From: Graham Evans
Sent: 09 December 2009 14:25
To: Planning.Responses
Subject: FW: Planning Consultation on: BR/274/09/

APPLICATION NO: BR/274/09/

Registered: 23-NOV-09
Site Address: 2 Waterloo Square Bognor Regis PO21 1SU

Description of Works: Change of use from arcade (Sui Generis) to restaurant (A3)

EXTRACTOR
SYSTEM

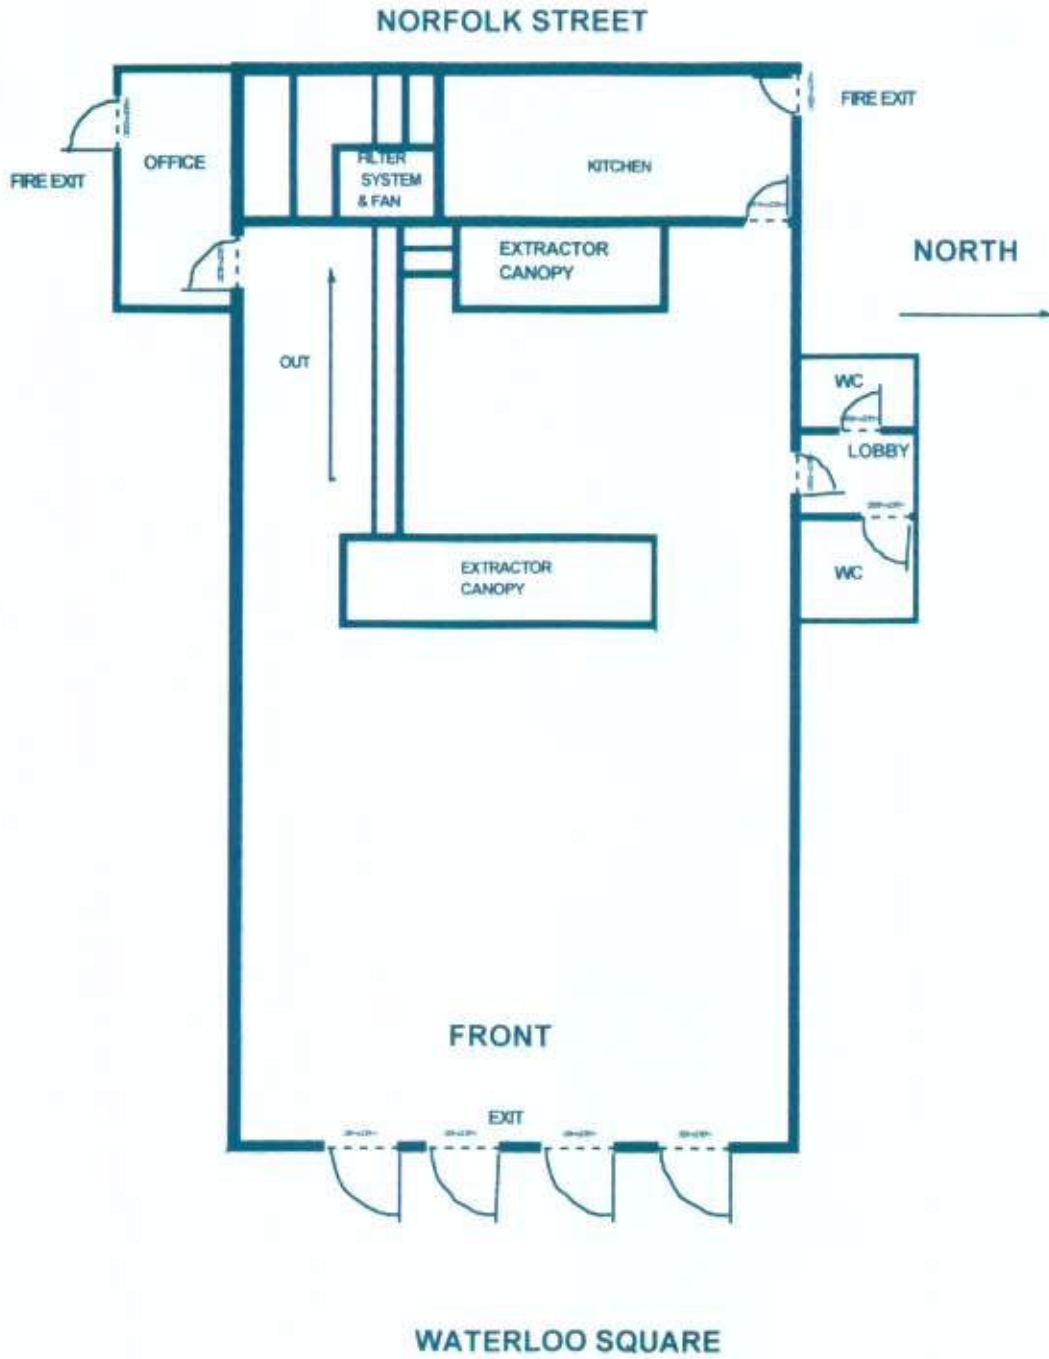
However, it has been noted that the simple drawing on page 3 of the 'Bin Storage and Extraction Plans' document appears to indicate a horizontal discharge from the stack. This is poor practice, and therefore this Department strongly recommends that the design should be revised to offer an unimpeded vertical discharge.
